Annex 1 – Oxfordshire County Council’s response to Cherwell District Council’s consultation dated 14 March 2011 on AMENDED application for Phase One North West Bicester Eco-town (no: 10/01780/HYBRID): Detailed comments

2. Social and Community Infrastructure: Proposed School Site

3. Transport

Drawing no. 8020-UA01881-UP23D-01

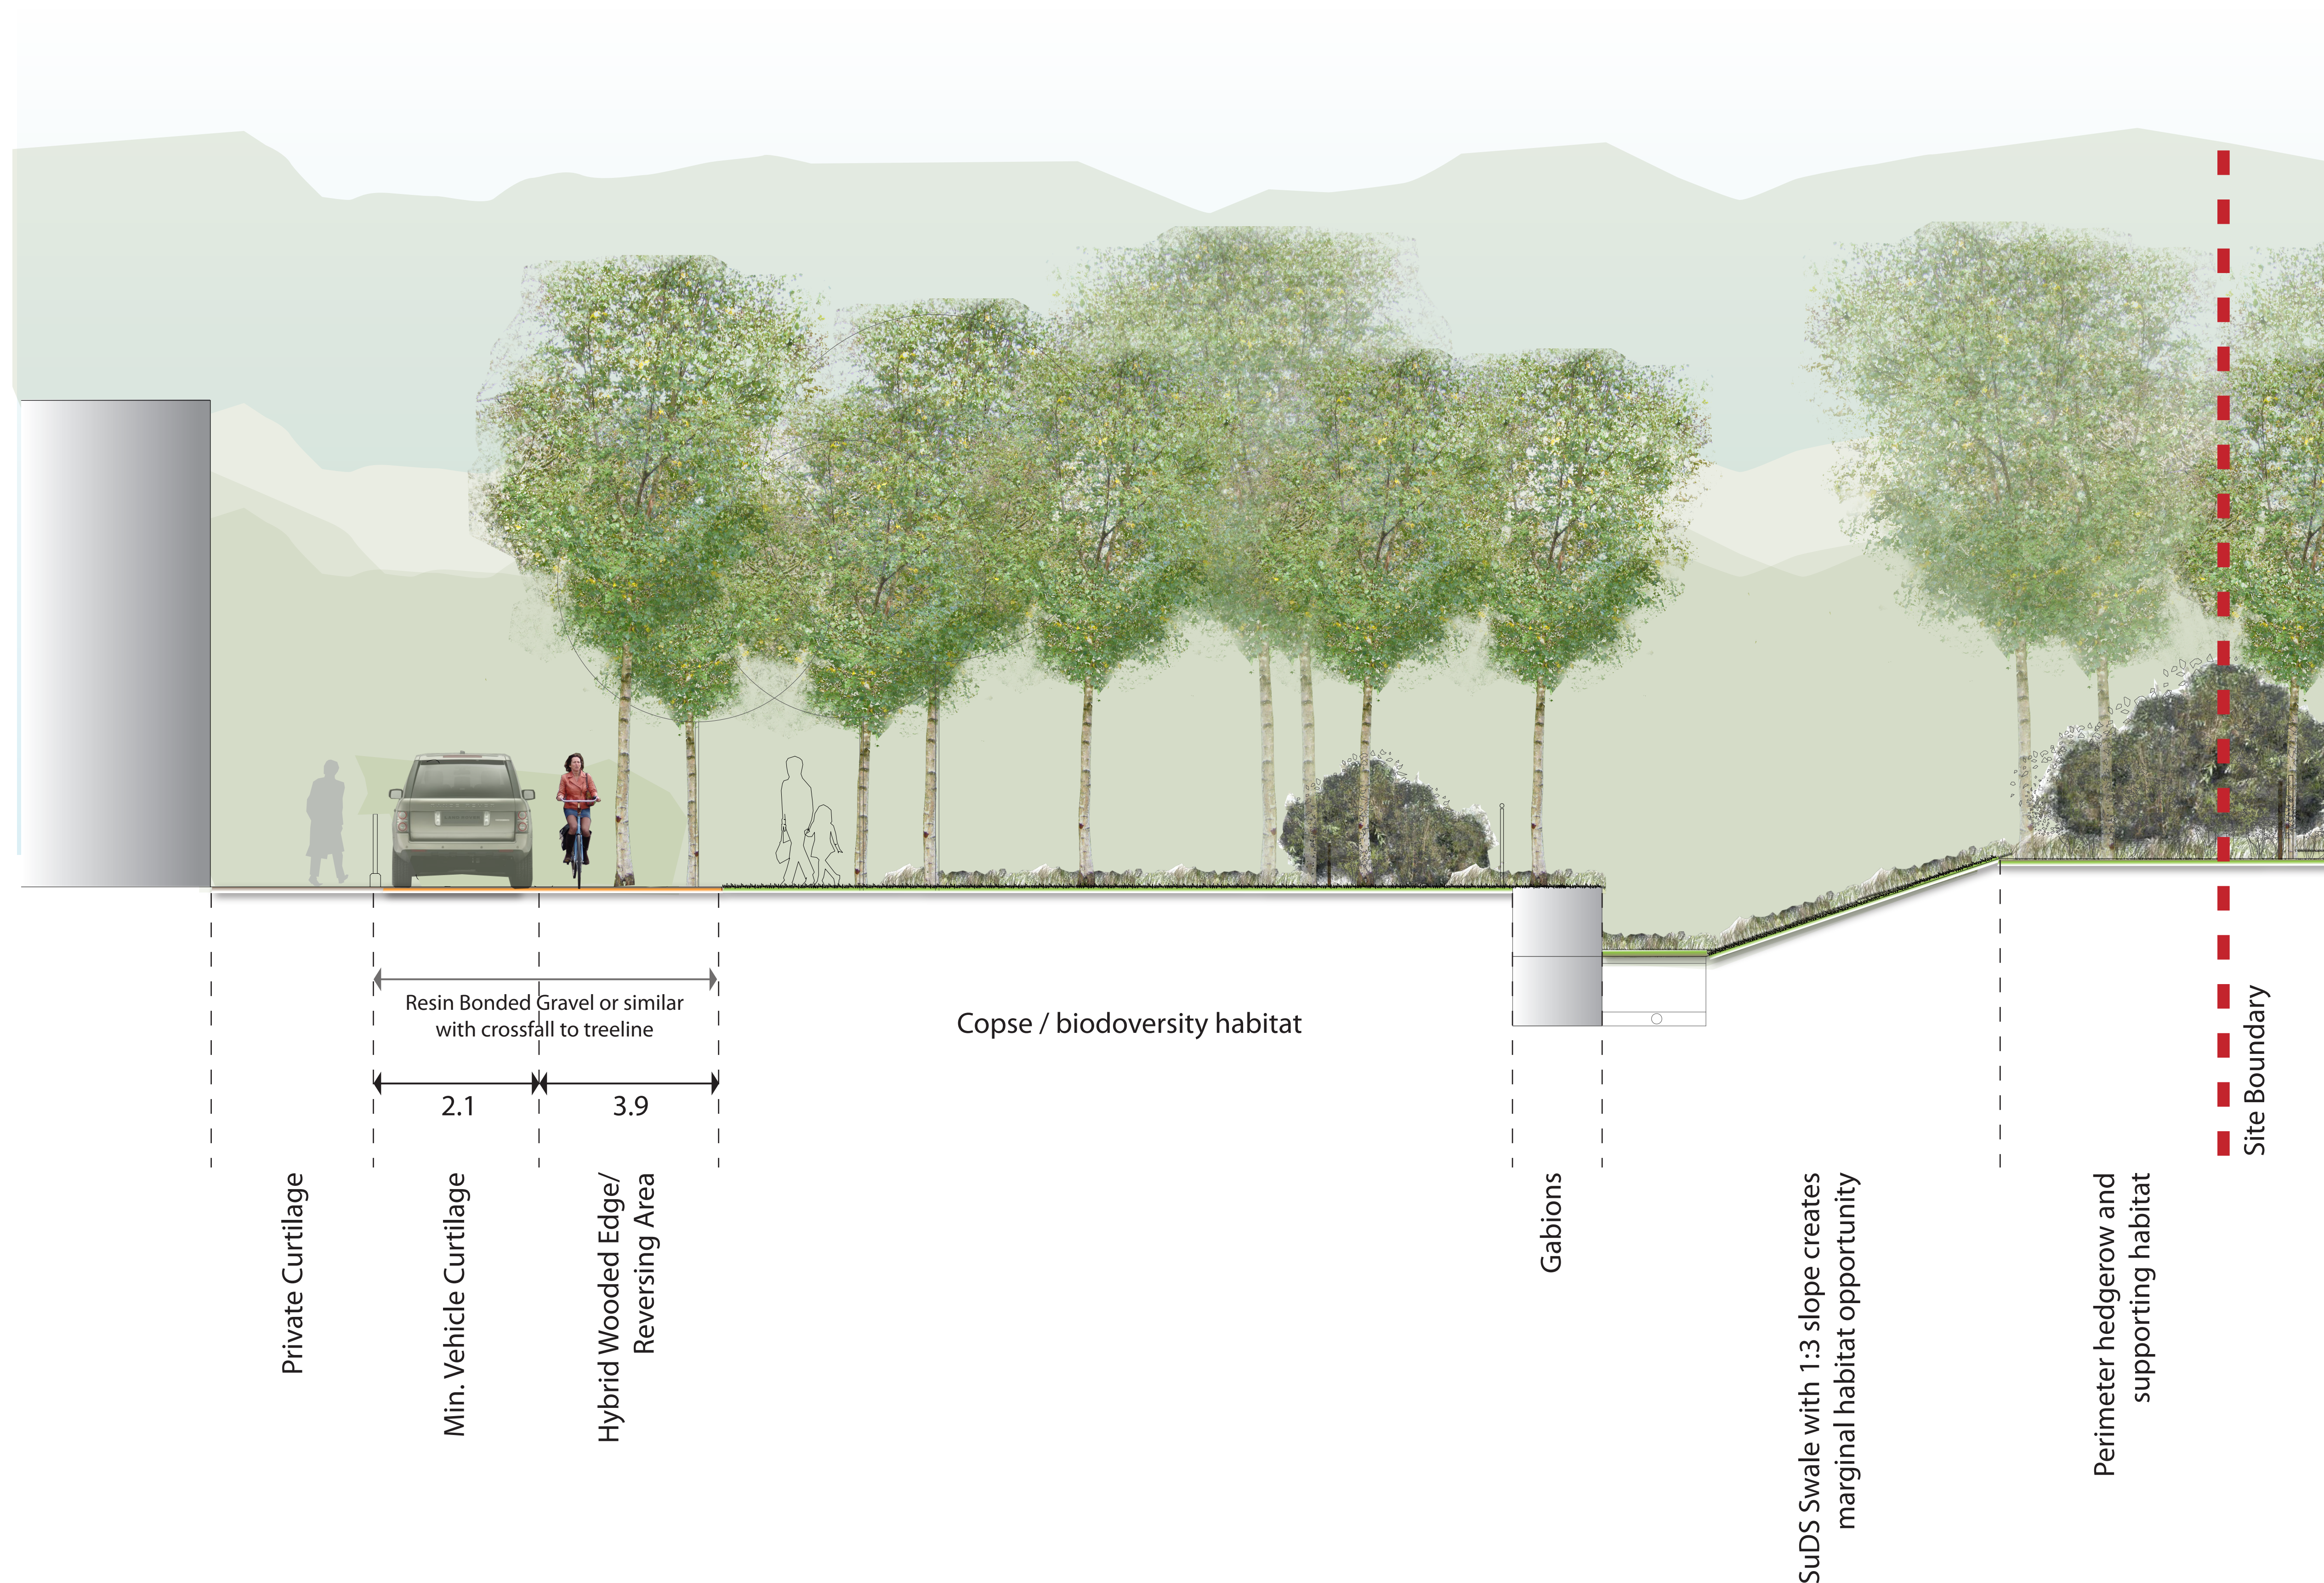
Drawing 8020-UA01881-UP23D-01 shows the minimum vehicle curtilage of 2.1m; this is not wide enough i.e. average family saloon car is 2.2m with wing mirrors – this plan needs to be amended to show 2.2m.

Drawing no: 8009-UA001881-UP23D-02

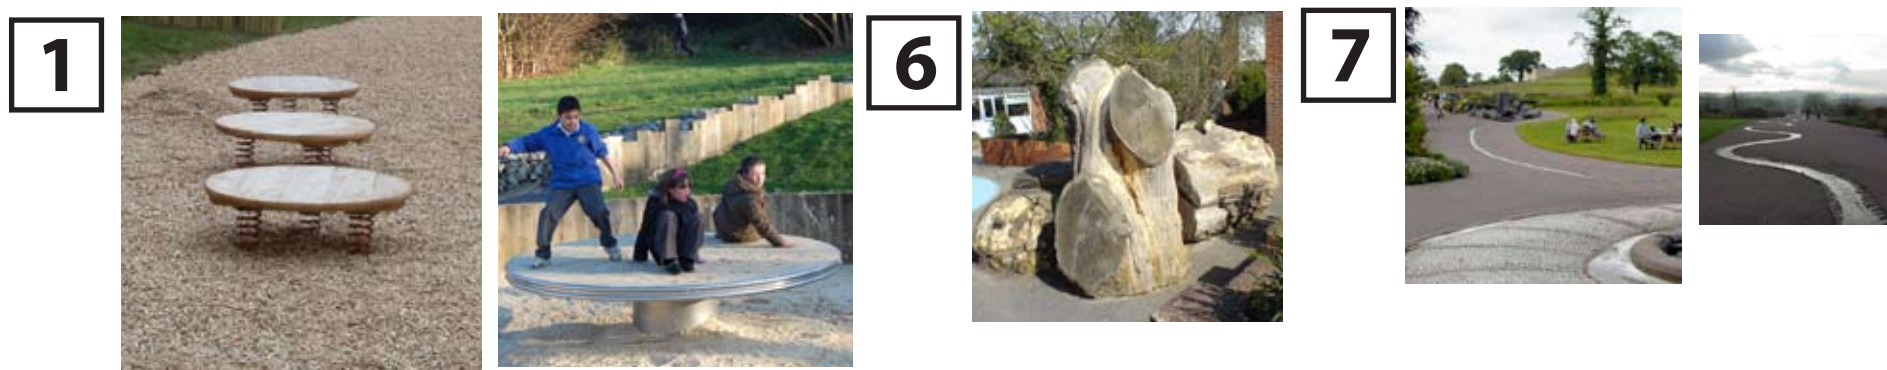
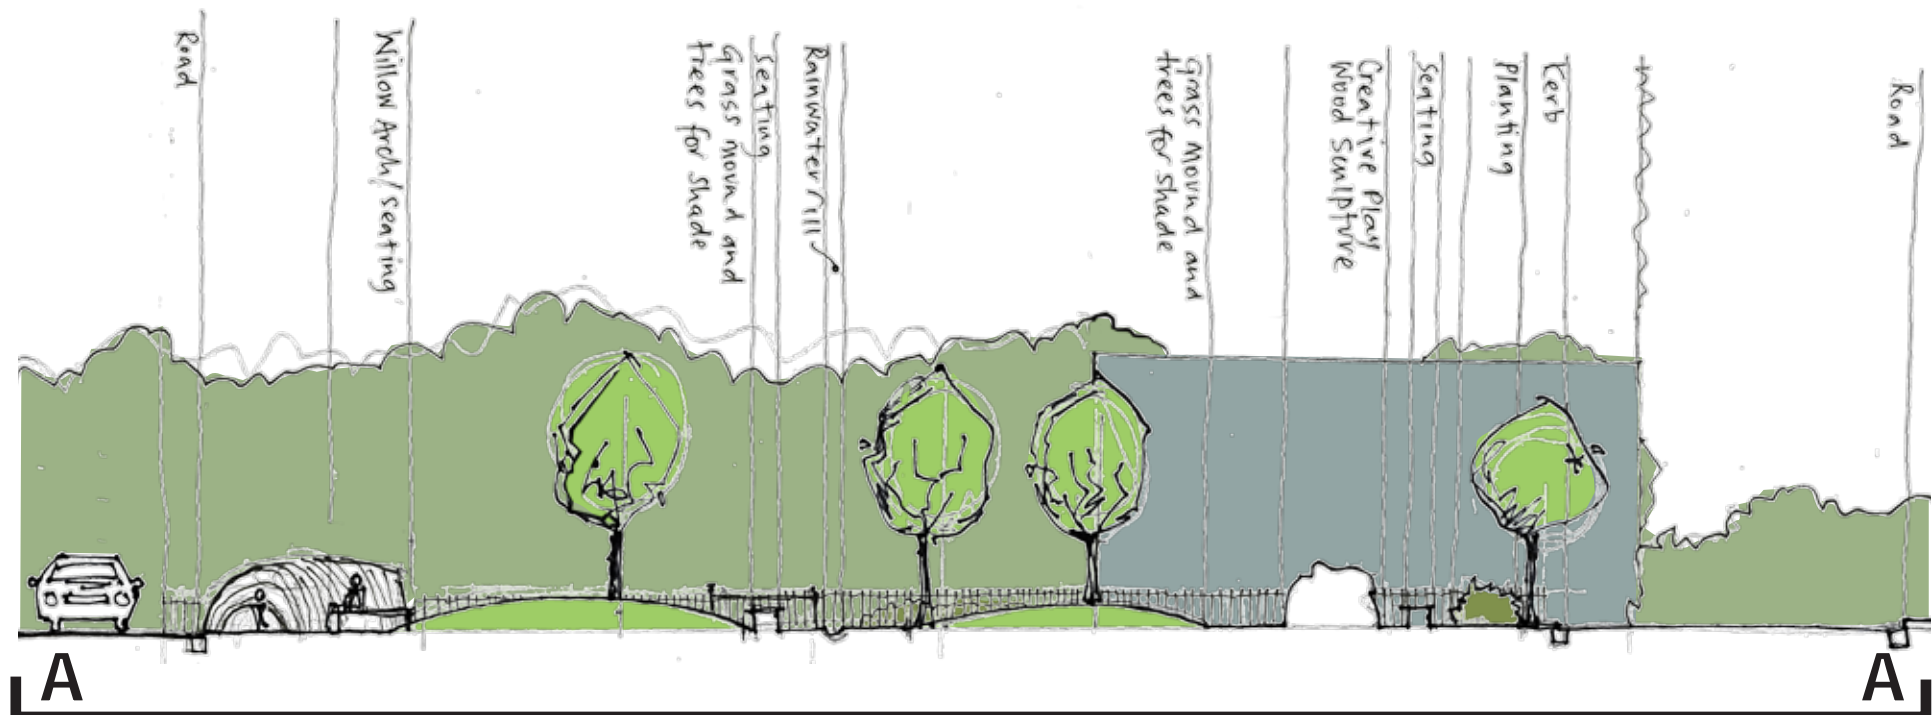
Drawing 8009-UA001881-UP23D-02 it is unclear where the highway boundary is for this village green LEAP: currently appears that proposed gates open over the public highway which is not acceptable.
